Arun District Council
Arun Civic Centre
Maltravers Road
Littlehampton
West Sussex BN17 5LF
Planning & Building Control General Enquiries
Tel: (01903) 737756 Fax: (01903) 730442
Dx: 57406 Littlehampton
Minicom: 01903 732765
e-mail: planning@arun.gov.uk
website: www.arun.gov.uk/planning

Application No: R/60/22/PL
Site Address: The Windmill Inn Mill Lane Rustington BN16 3JN
Description of works: Extension and remodelling of existing public house to form hotel with 20 No bedrooms and associated parking and landscaping. This site is in CIL Zone 4 (Zero Rated) as other development.

Thank you for your internet representation made on 1st April 2022 which has been recorded as an objection with the comments as follows:

DRAWING TITLE
Proposed Ground & First Floor Plans

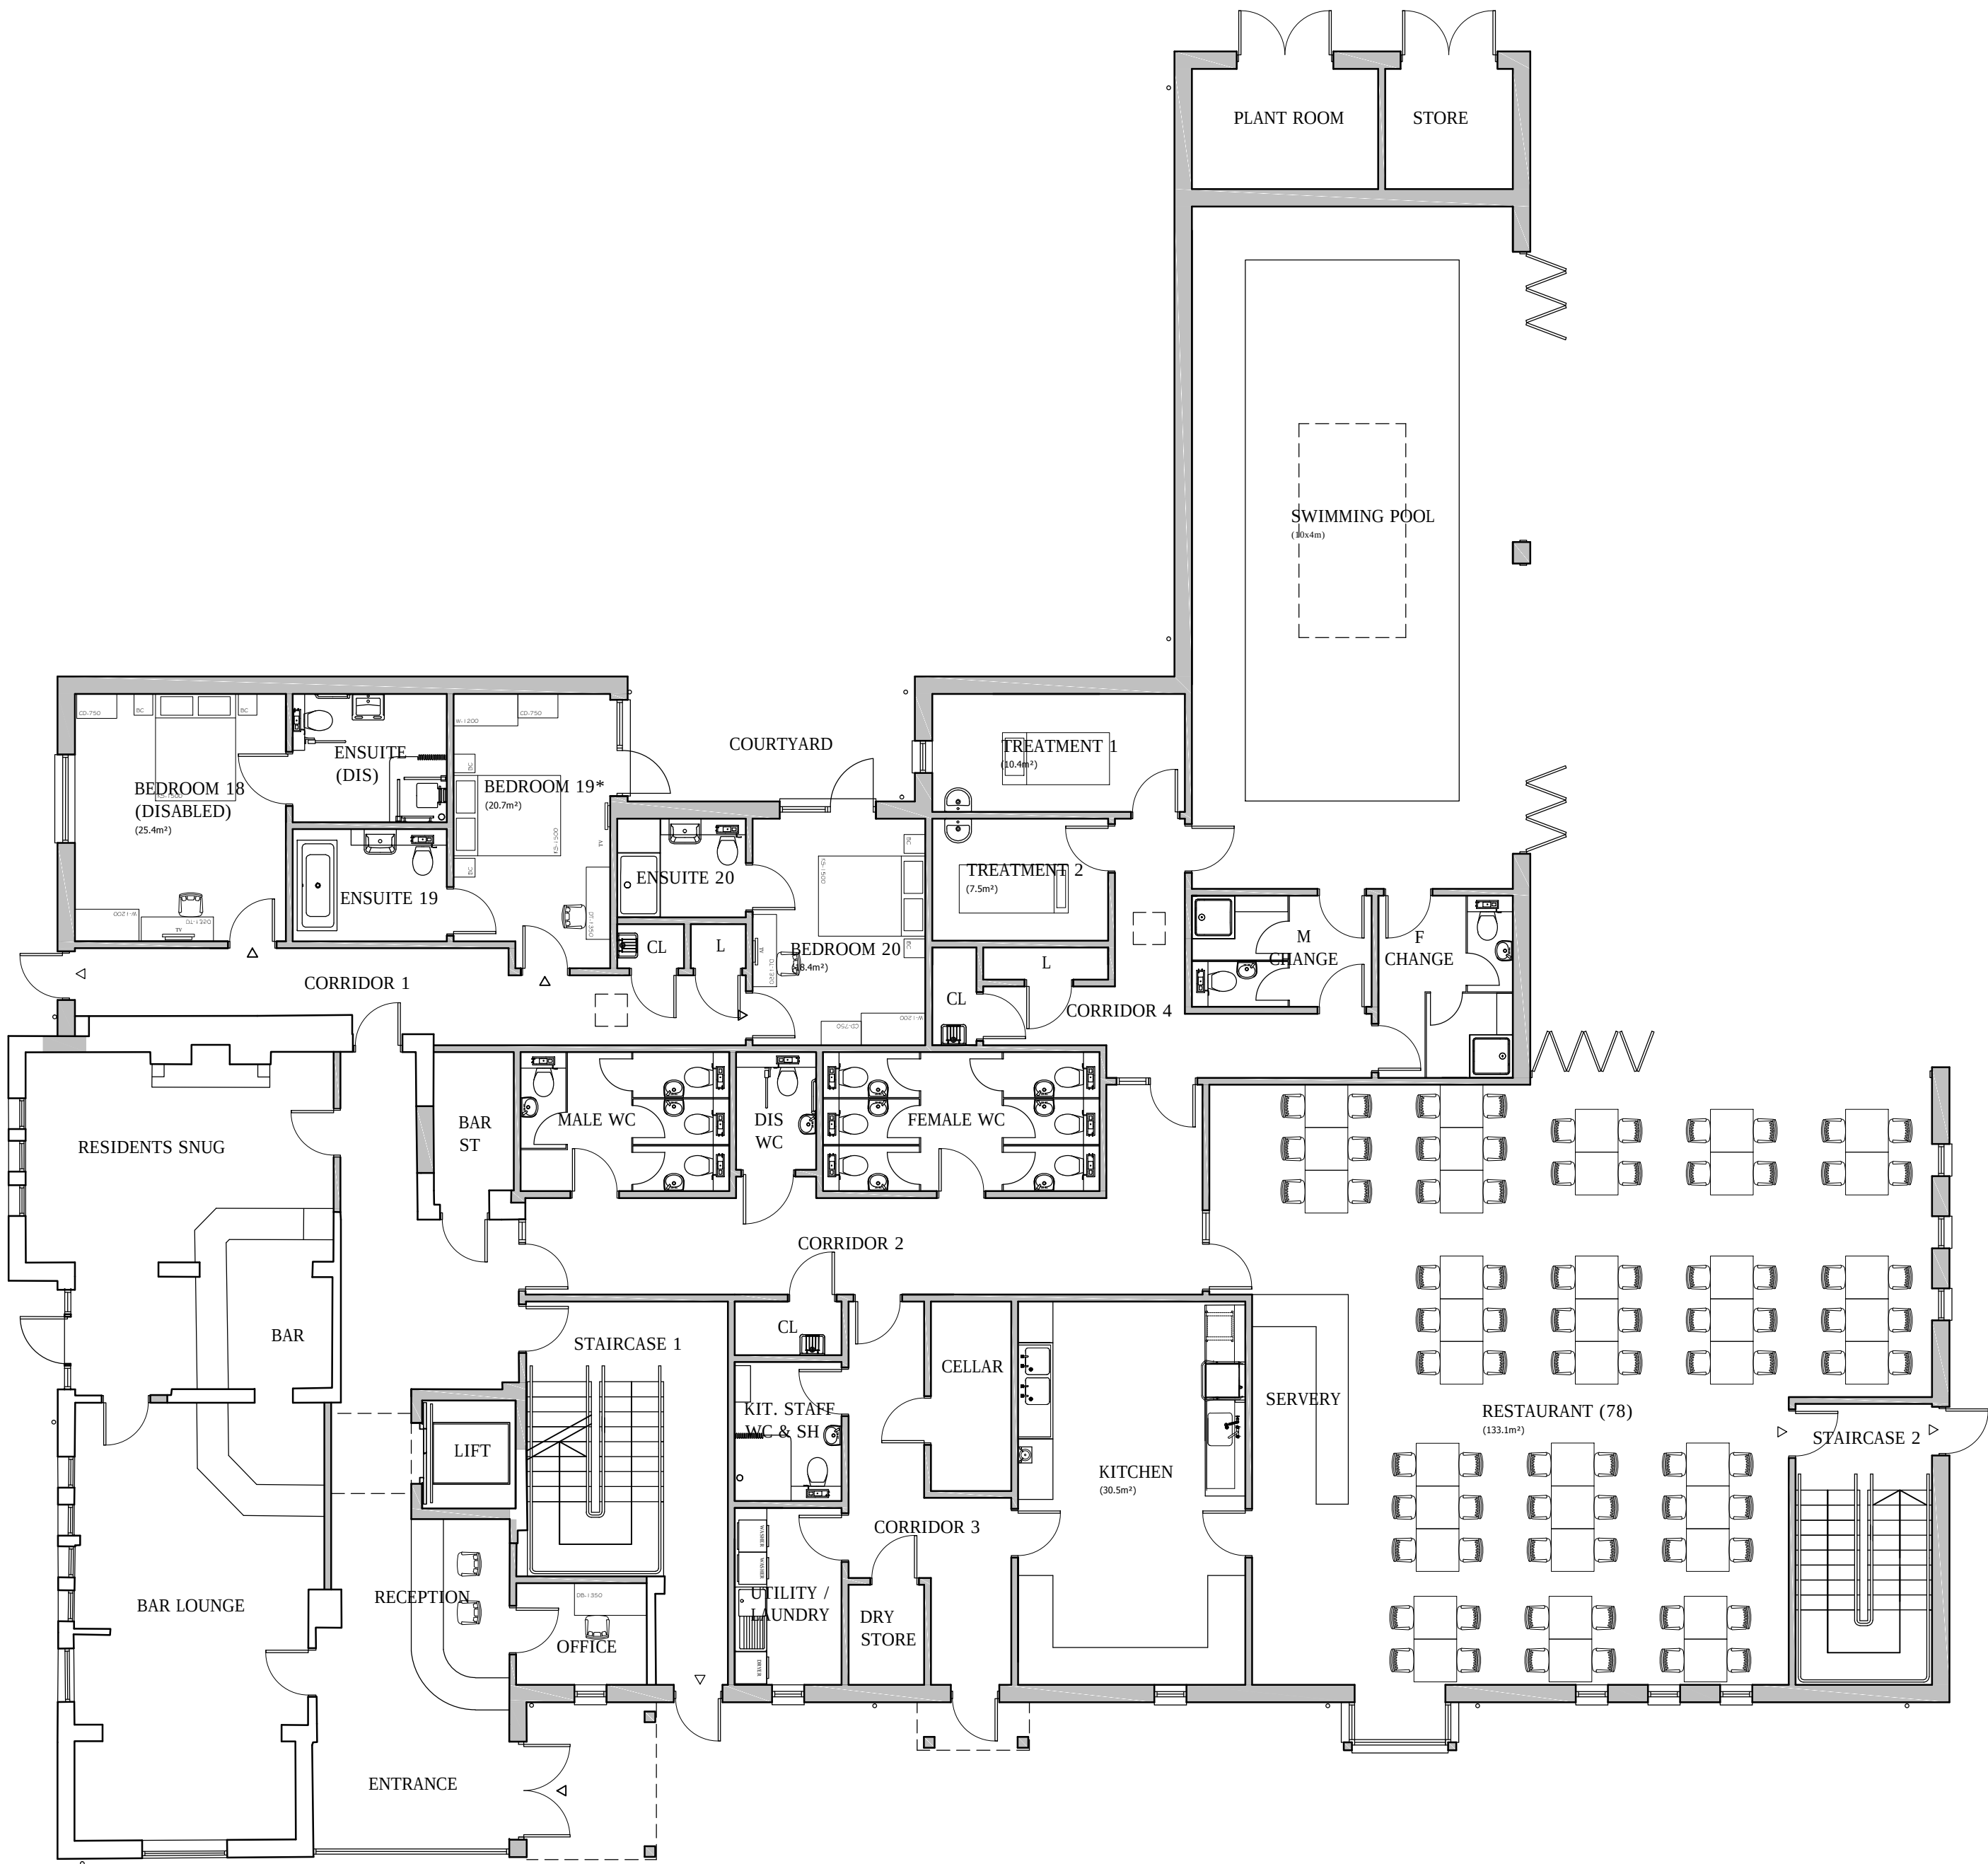
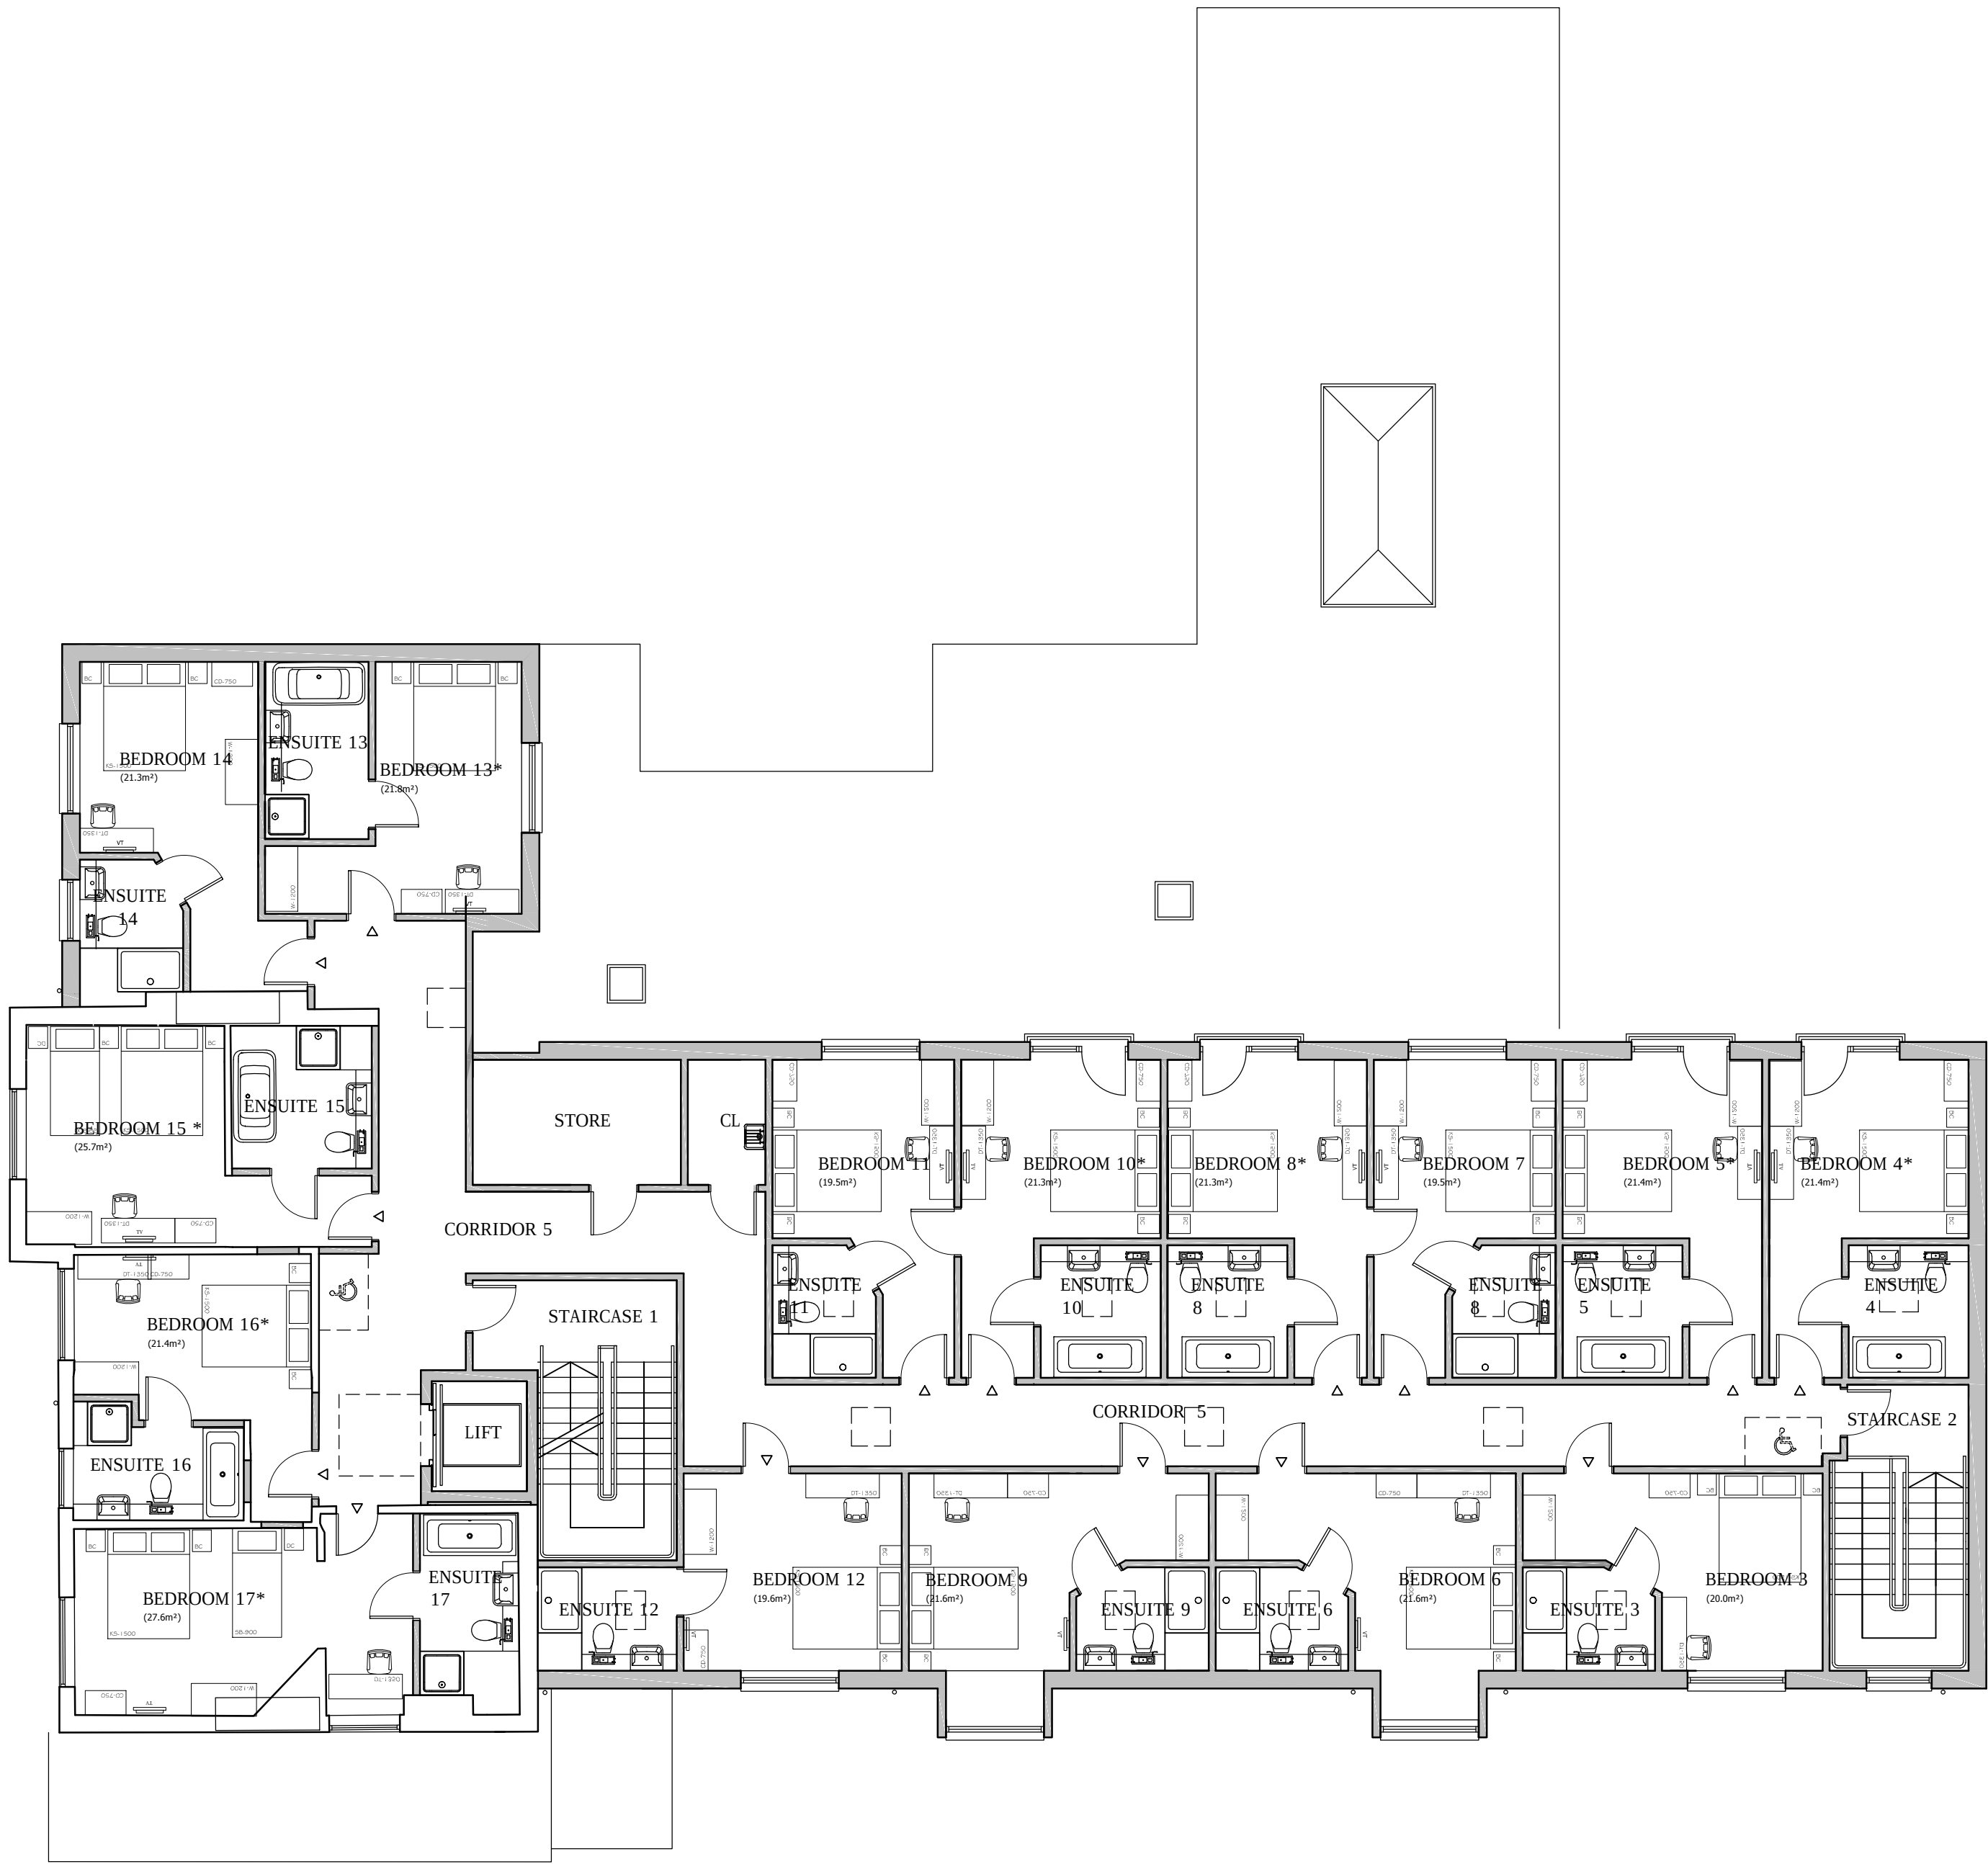
According to the application the galvanized steel duct work that would vent the proposed commercial kitchen will be venting 1000mm above any roof ridge within 20 mts of the kitchen. This does not appear to be shown on the drawings, possibly because it may be quite prominent and visually displeasing.

Drawing No.	2021-6377-001	Rev.	B
-------------	---------------	------	---

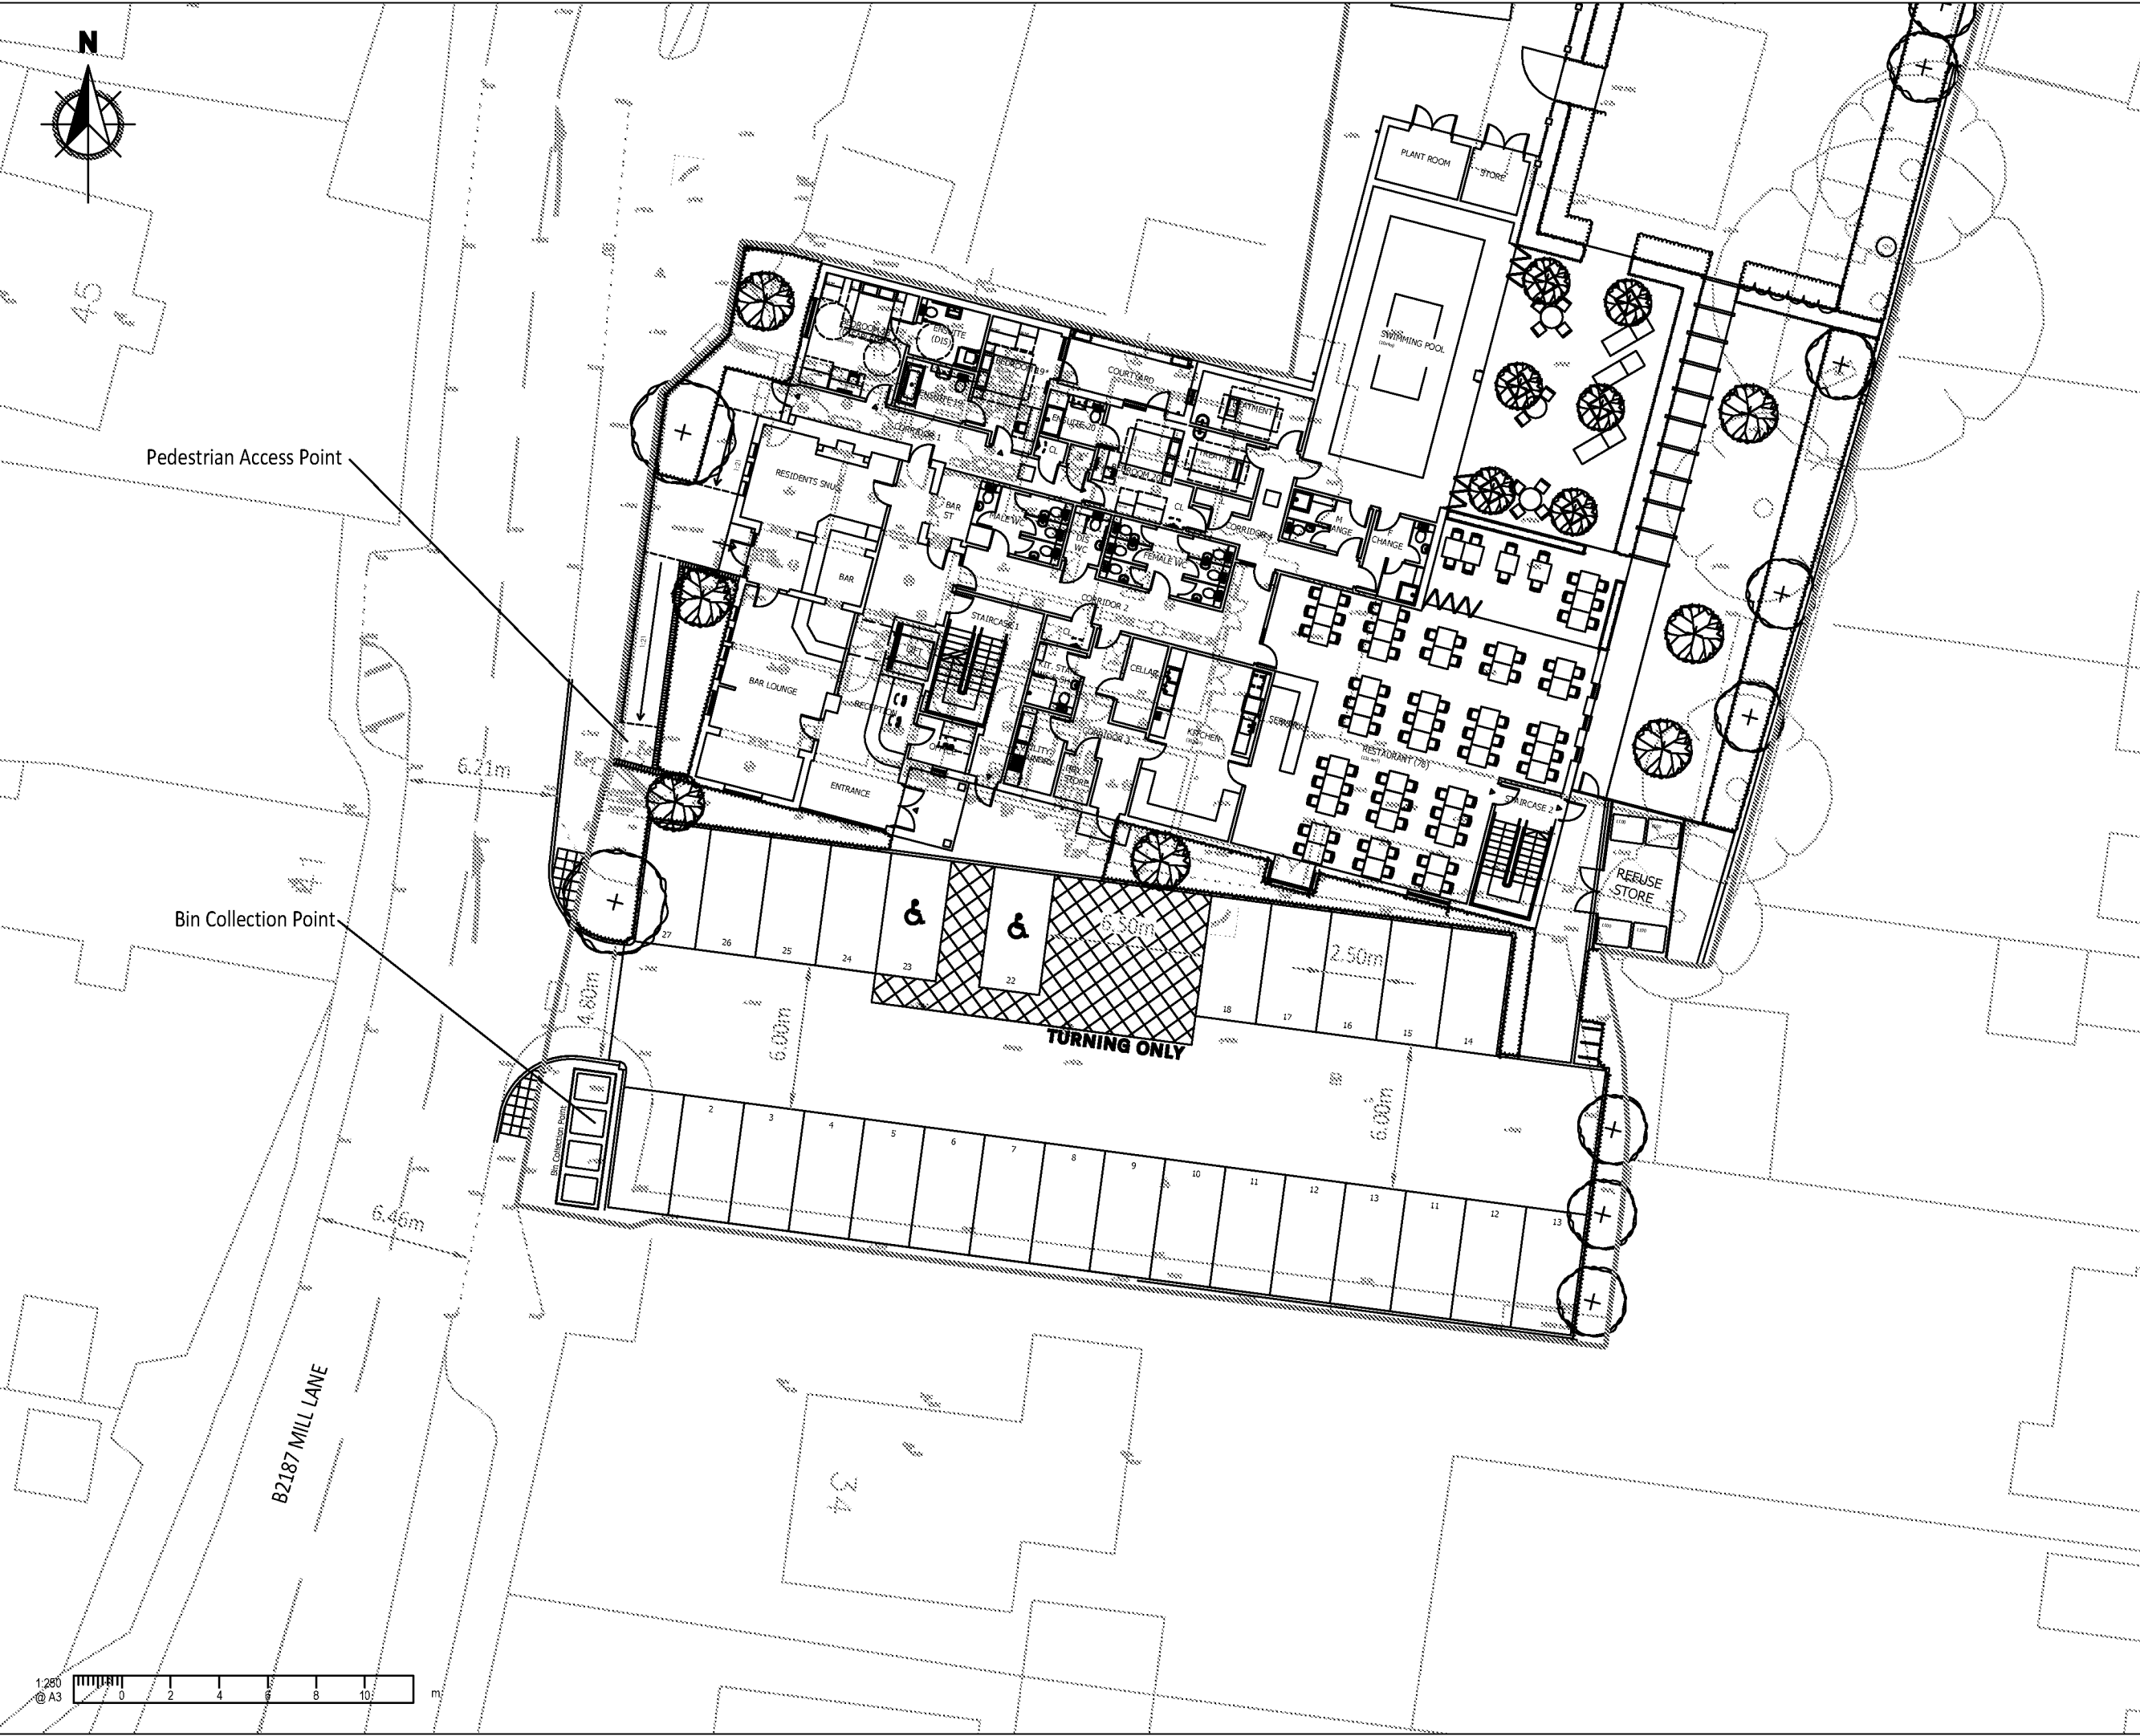
It states "however the presence of off-street parking facilities means the demand for on-street parking will be limited", only 27 parking spaces are proposed which according to the application is 3 less than they have now (as stated in the application vehicle and parking section), 20 of these will be allocated for hotel rooms leaving only 7 spaces.
